From: Sue Howell
Sent: 06 February 2018 16:46
To: Planning.Responses
Cc: Simon Davis
Subject: RE: Planning Consultation on: Y/74/17/RES

Further comment from Greenspace

Comment from Greenspace

APPLICATION Y/74/17/RES

16024-RM-112

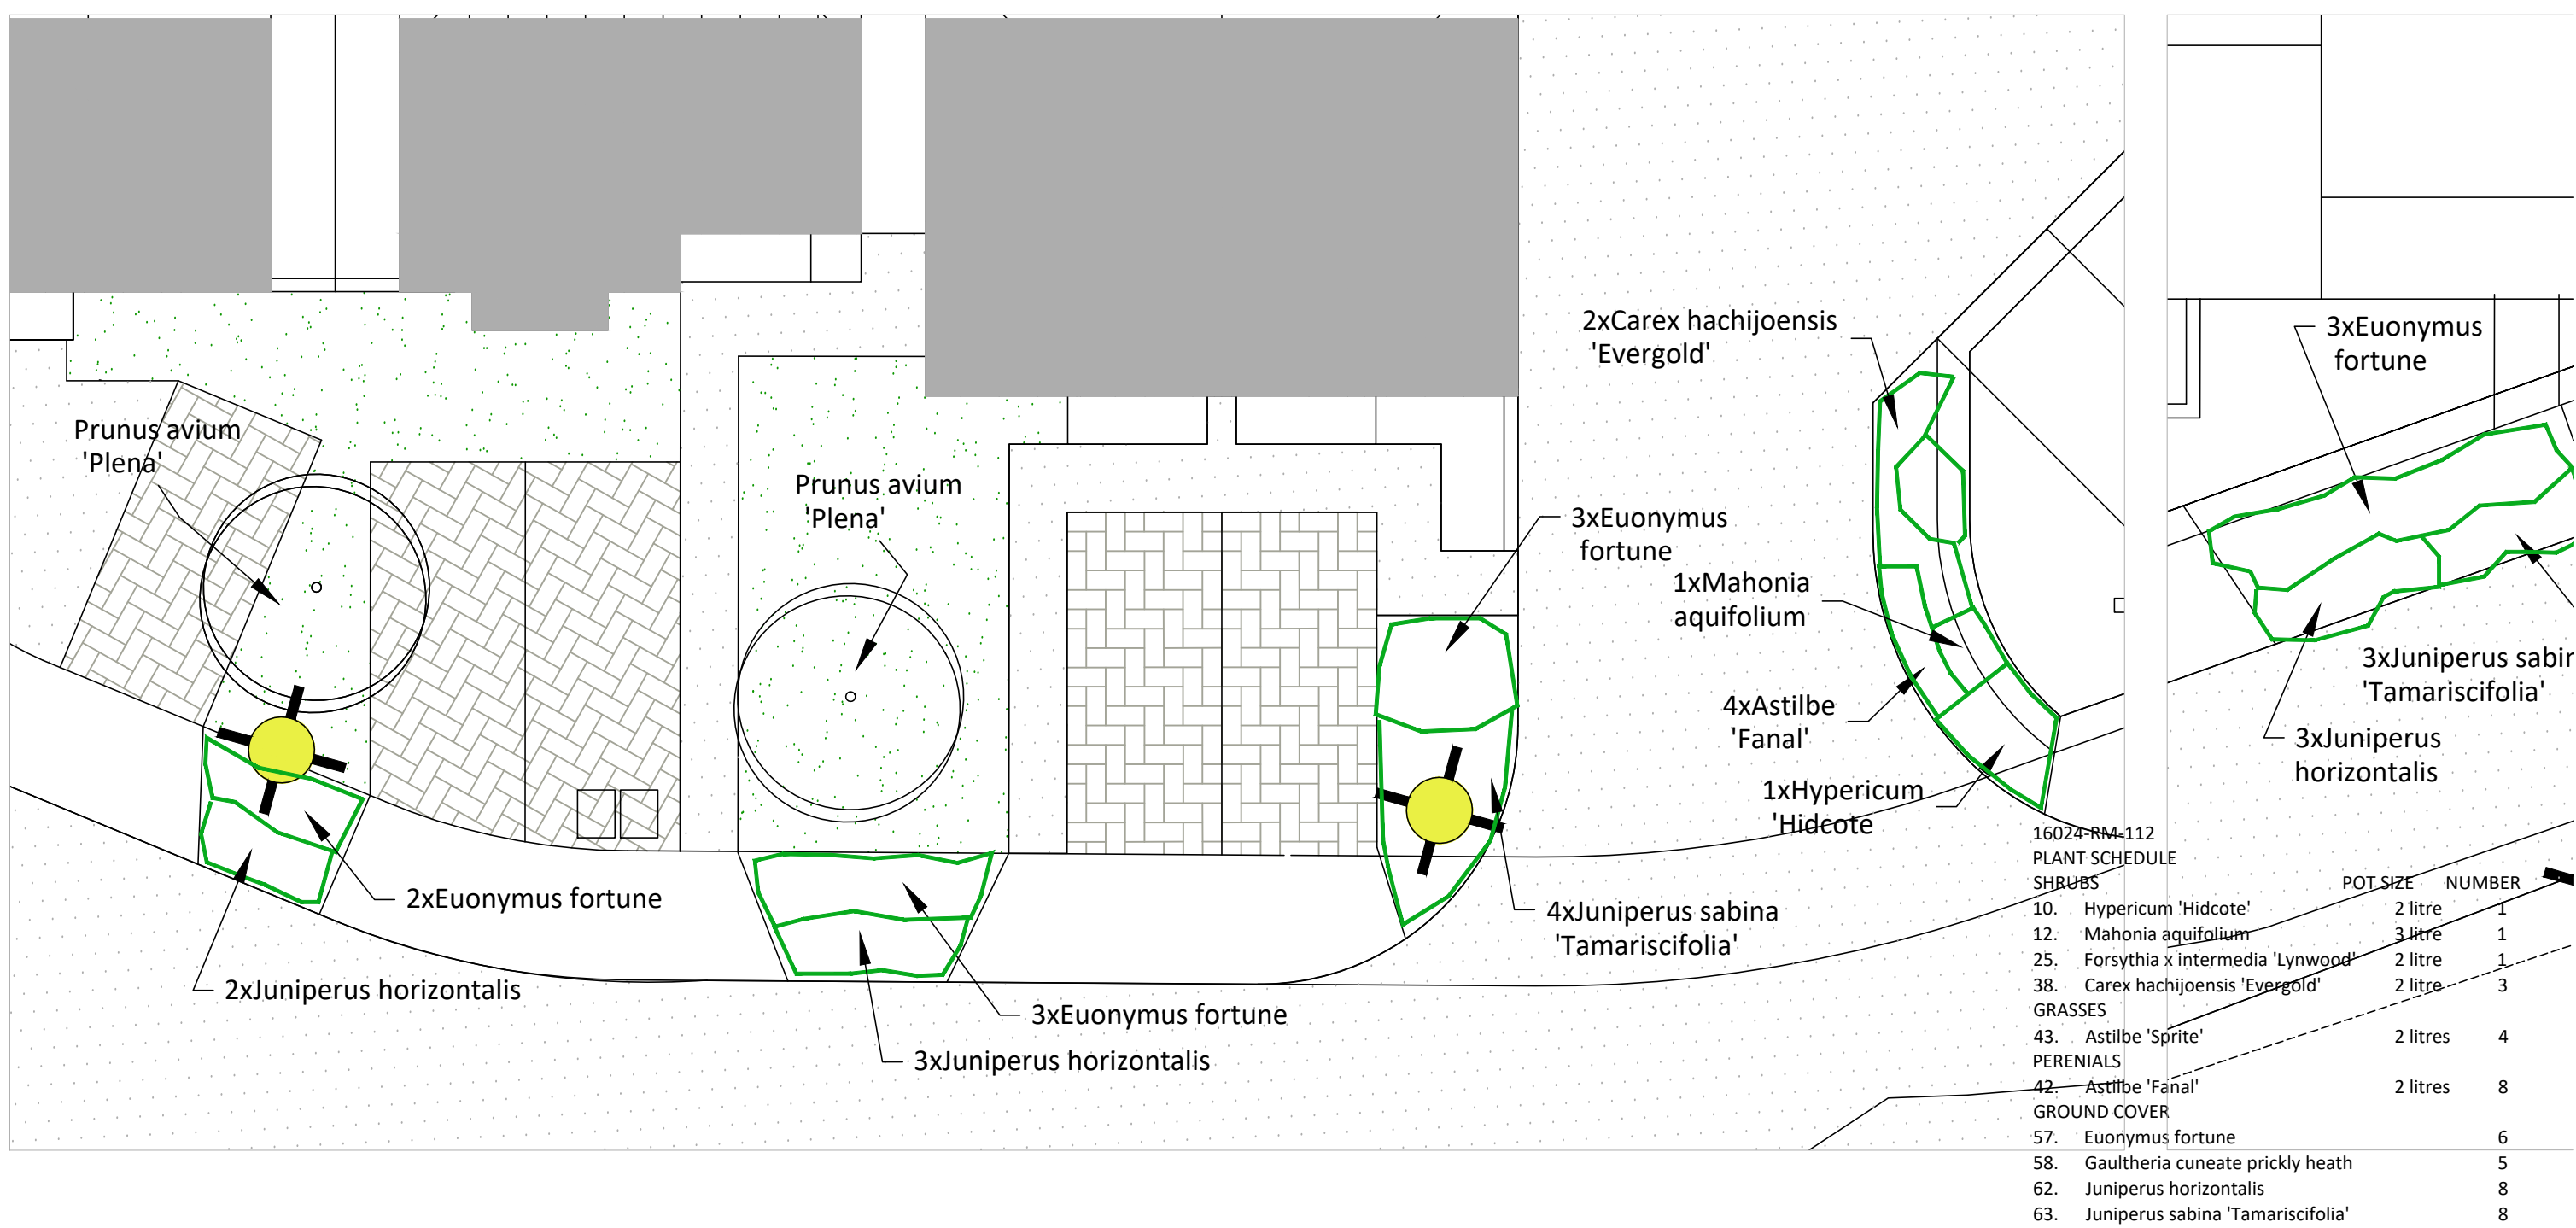
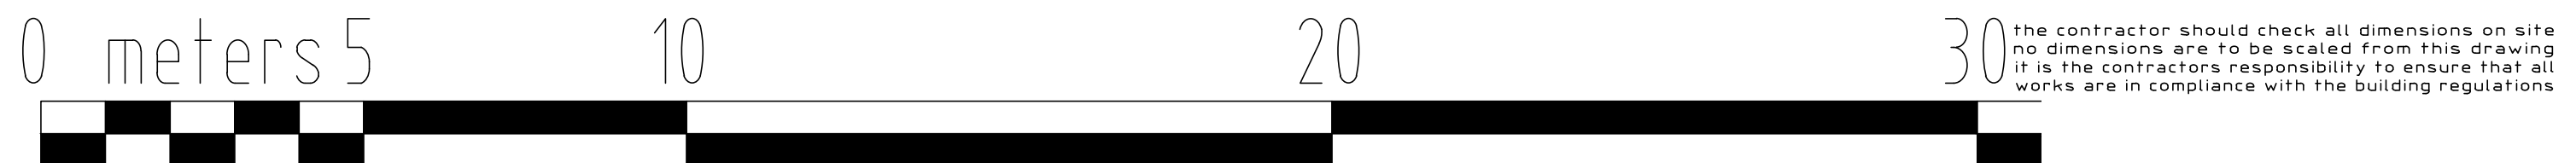
This application has included a detailed landscape scheme with trees, shrubs, grasses, perennials, hedging and groundcover that are both suitable and fitting for location. The 'Site layout-Landscape layout drawing 16024-RM110 D whilst contains details of species type, size and planting density does not include the plant quantities being proposed, which we would recommend are a requirement in plan form.

Our recommendation therefore would be that this drawing is amended to show actual quantities in location rather than just detail of the variety for location.

Further to the submission of additional drawings 16024-RM-111-115 inclusive submitted in addition to 16024-RM110 E; we would now recommend that the information submitted is compliant in detail and that we would now recommend that we have no objections to the proposals submitted under reserved matters application Y/74/17/RES following consent under Y/22/14/
